Response to Submissions relating to Modification to MP 08_0170 (Mod 2)

Newcastle Private Hospital

158 Croudace Street, and 14 & 20 Lookout Road,
New Lambton Heights

November, 2015

Project NEWCASTLE PRIVATE HOSPITAL - EXTENSION & ALTERATIONS		Drawing GROUND FLOOR PLAN - LINK	
Client Healthscope	Scale 1:200 @ A1	Date Printed 11/3/2015 10:08:43 AM	Issue
Location 14 LOOKOUT ROAD, NEW LAMBTON HEIGHTS NSW	Project Number 203046	Drawing Number SK210	Issue H

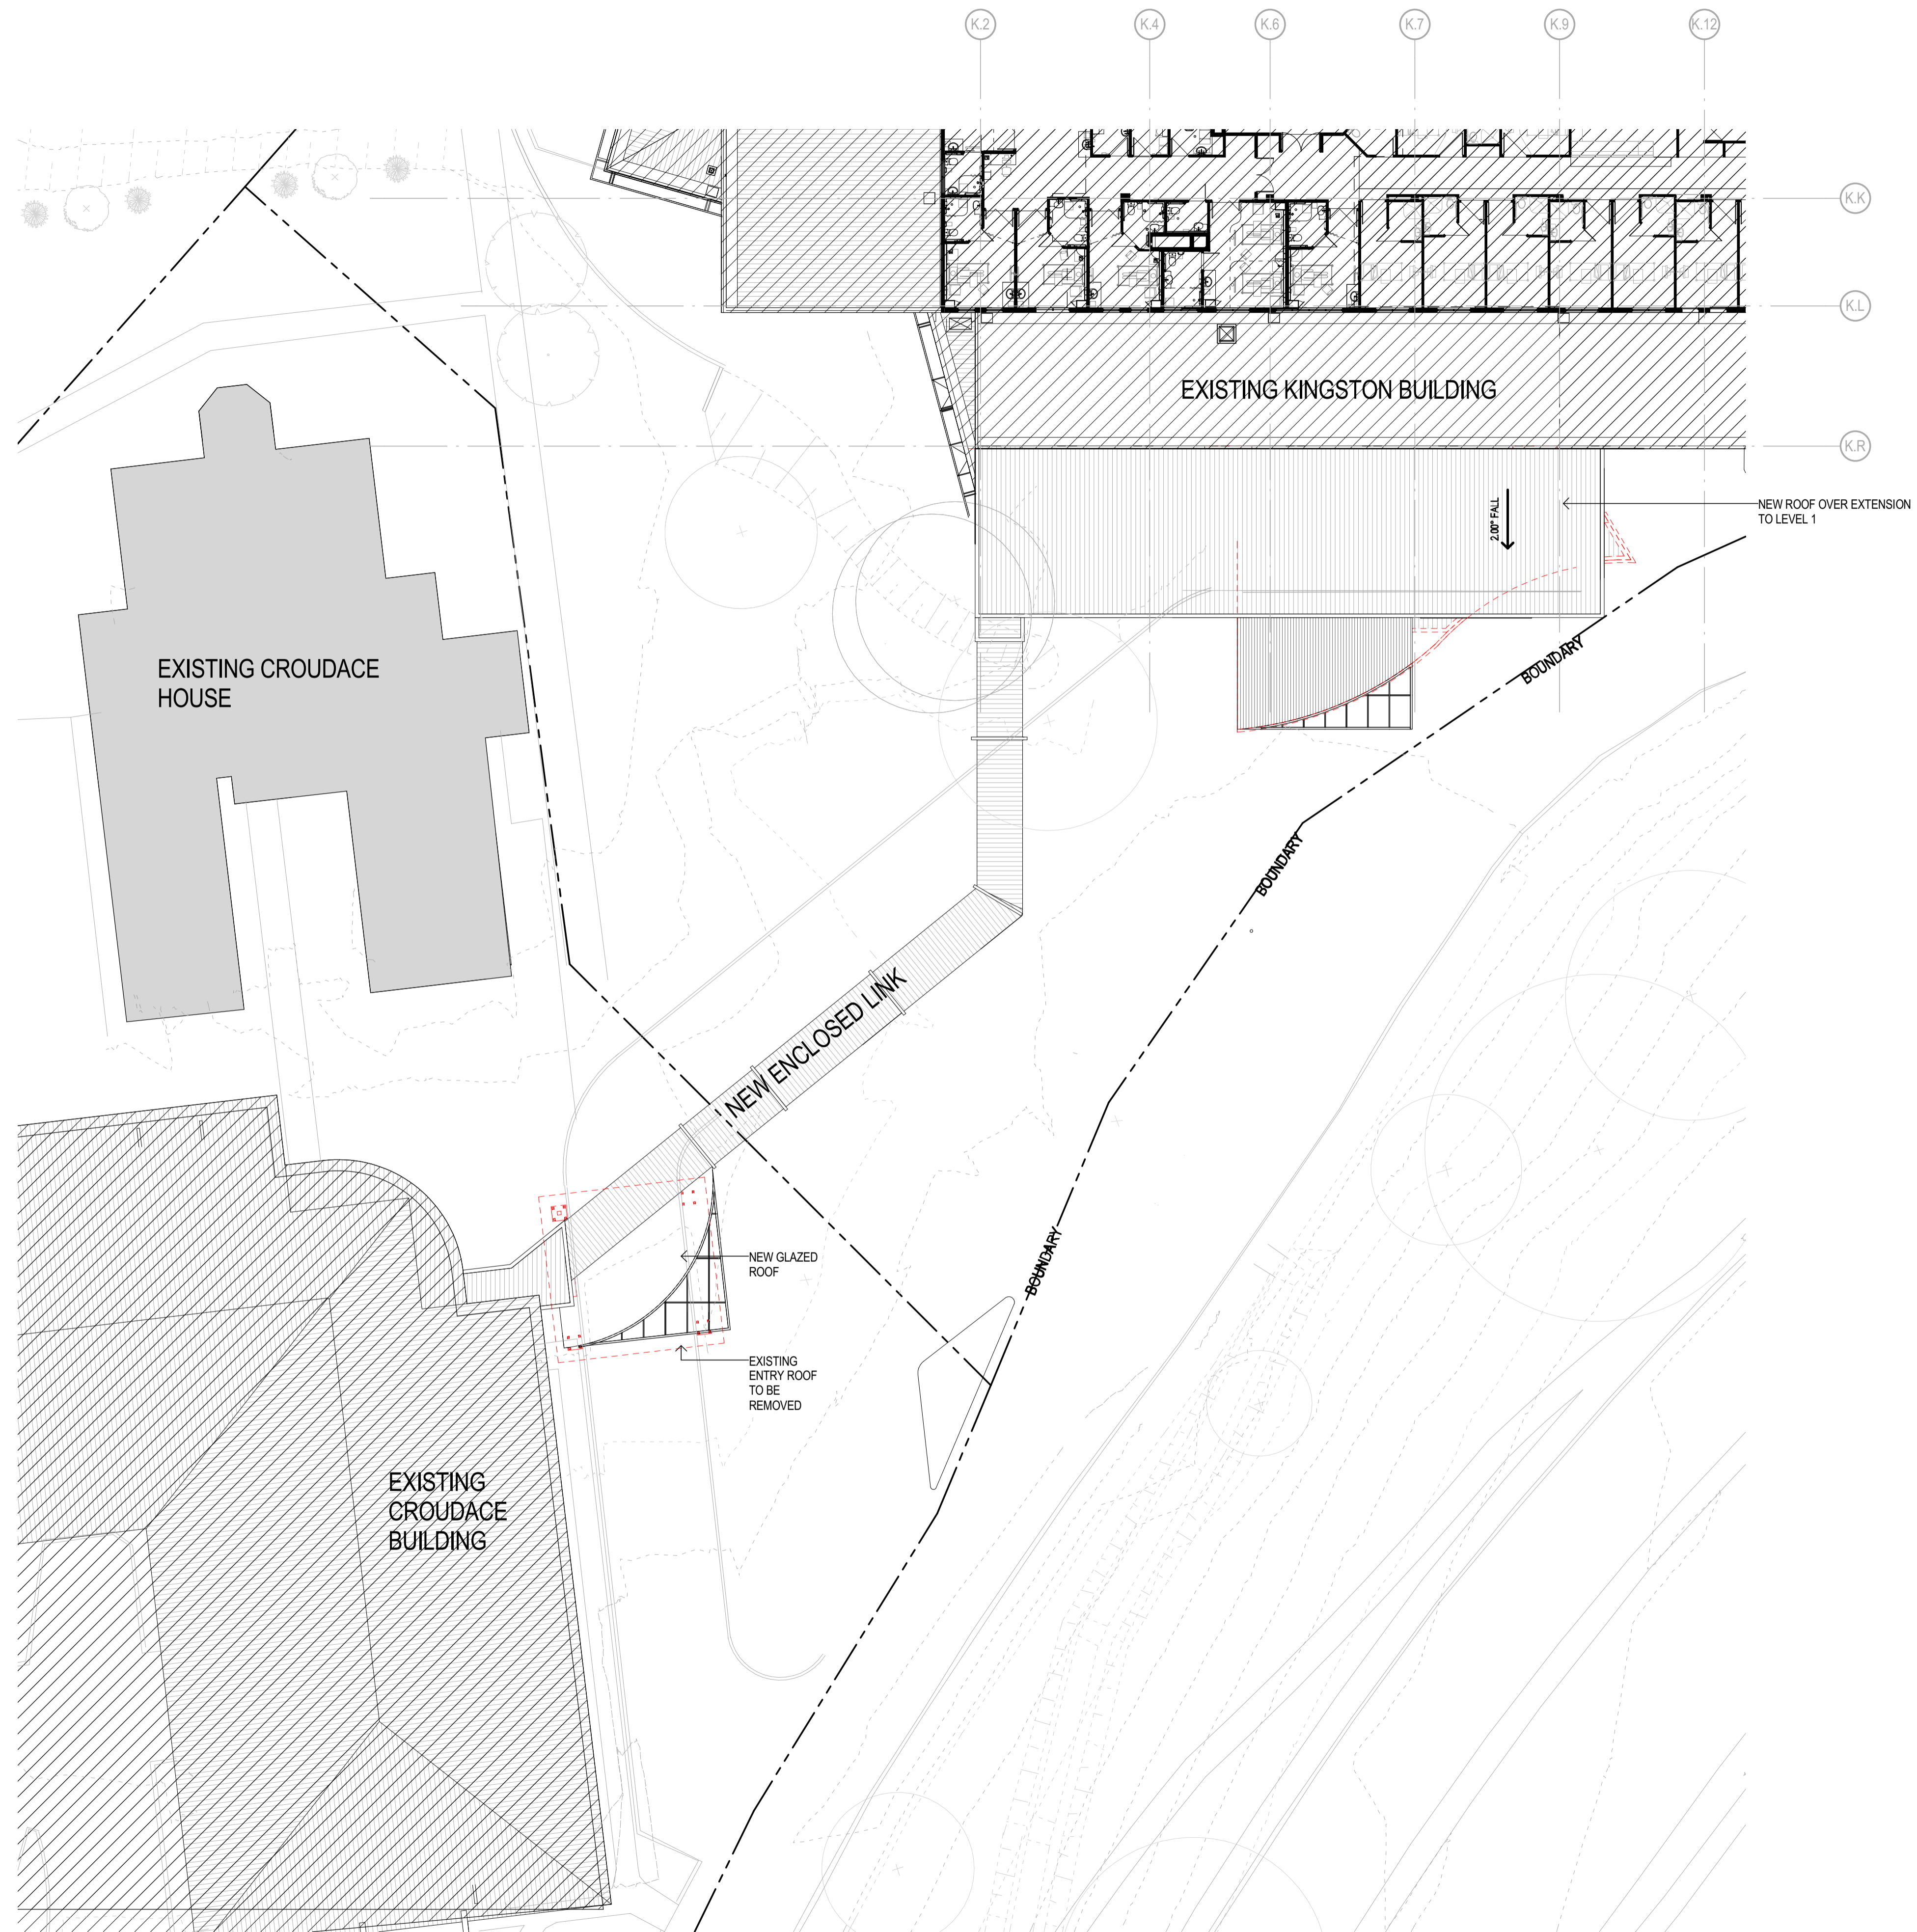
- *To minimise the potential for vehicular / pedestrian conflict it is recommended the design of the modified project be amended to include a designated pedestrian pathway within the new at-grade car park between bays No. 5 to 14, and 24 to 31, linking to the 'Kingston' and 'Croudace' buildings.*

- A pedestrian footpath addition is proposed adjoining the accessible parking bay (bay 31 and associated shared zone) in the at-grade car park. The footpath addition will direct pedestrians from the lower level of the car park to the footpath linking to the Kingston Building and subsequently the Croudace Building. Drawing SK210 (at **Appendix B**) has been amended to identify the access pathway addition.

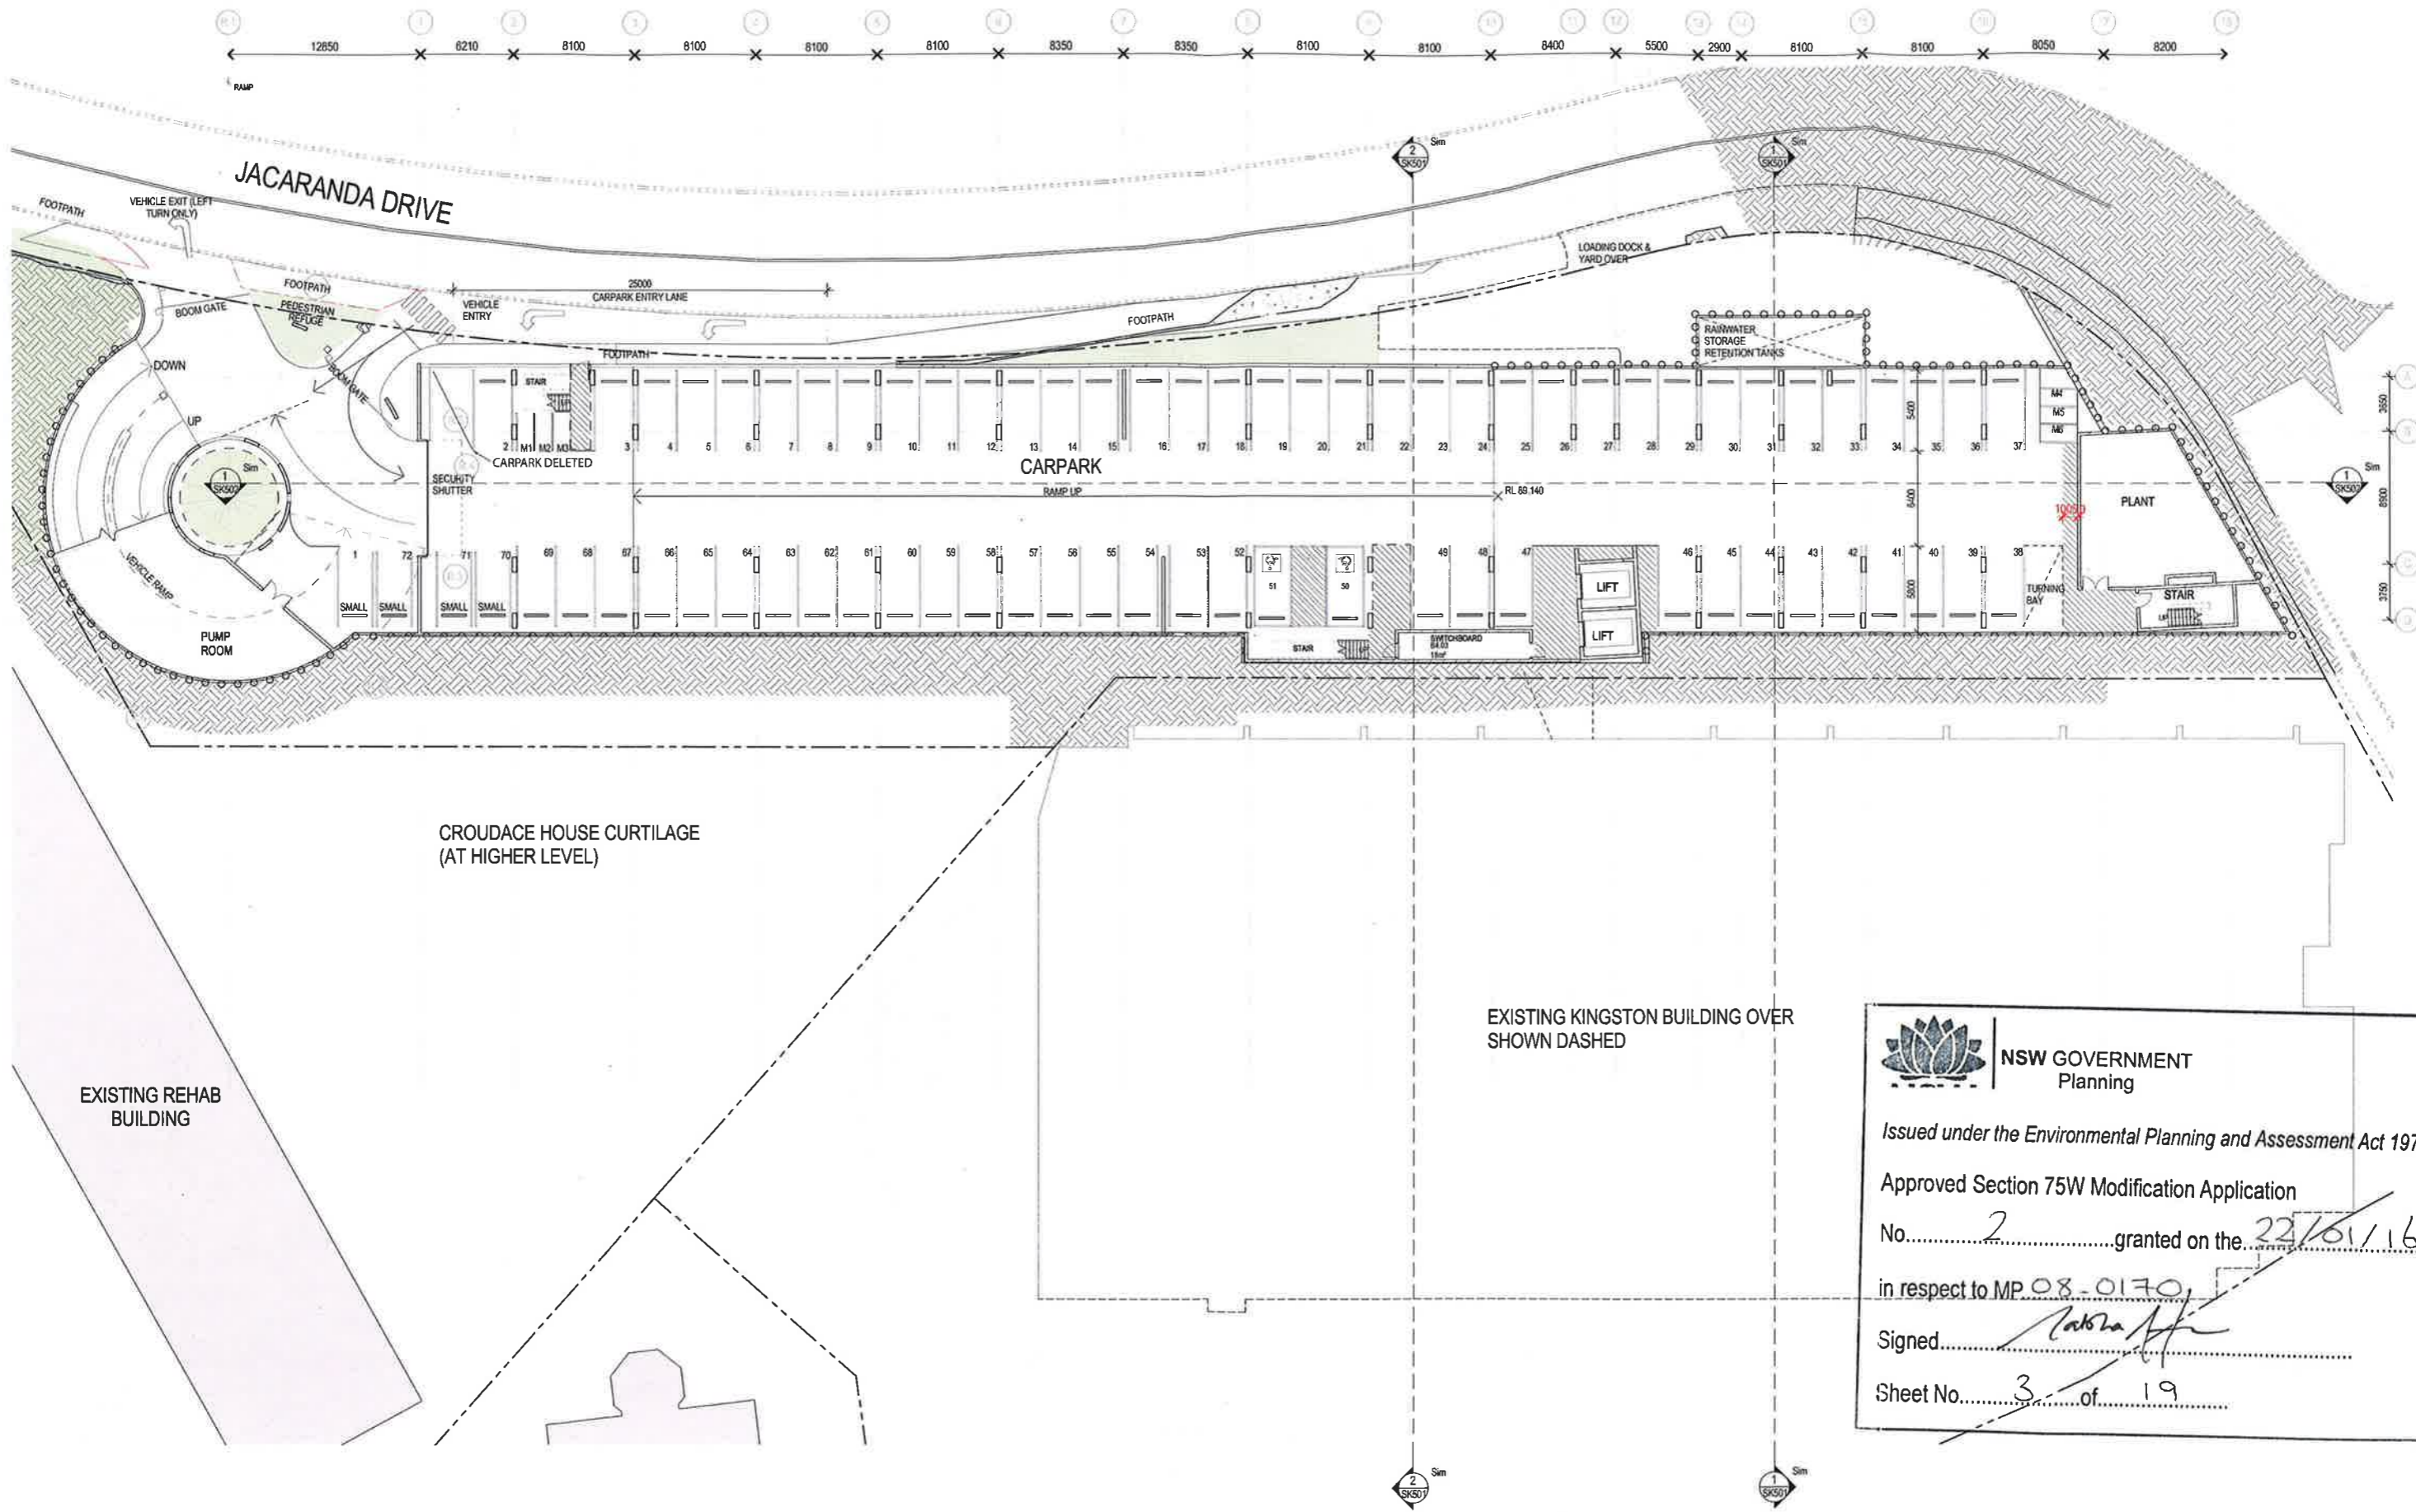
- *Council's previous submission of 24 July, 2009 raised safety concerns in the relation to the proximity of proposed parking spaces to the access ramps at each level in the parking station. Driver sight lines are considered to be compromised thereby increasing the potential for vehicle conflict. This issue has not been addressed by the traffic consultant's report and needs to be reviewed and resolved prior to the determination of the modification request.*

- Deletion of three (3) parking spaces within the basement levels (one (1) on each level (B3, B2 and B1) near the access ramps. The modification application initially submitted to DPE resulted in one (1) additional parking space (increasing the total from 382 to 383), and as such, the deletion of the three (3) parking spaces, will only result in a reduction of two (2) spaces, for a total parking provision of 380 spaces associated with the development.

The deletion of the basement car park spaces near the access ramps will provide for improved driver sight lines into and out of the car park.
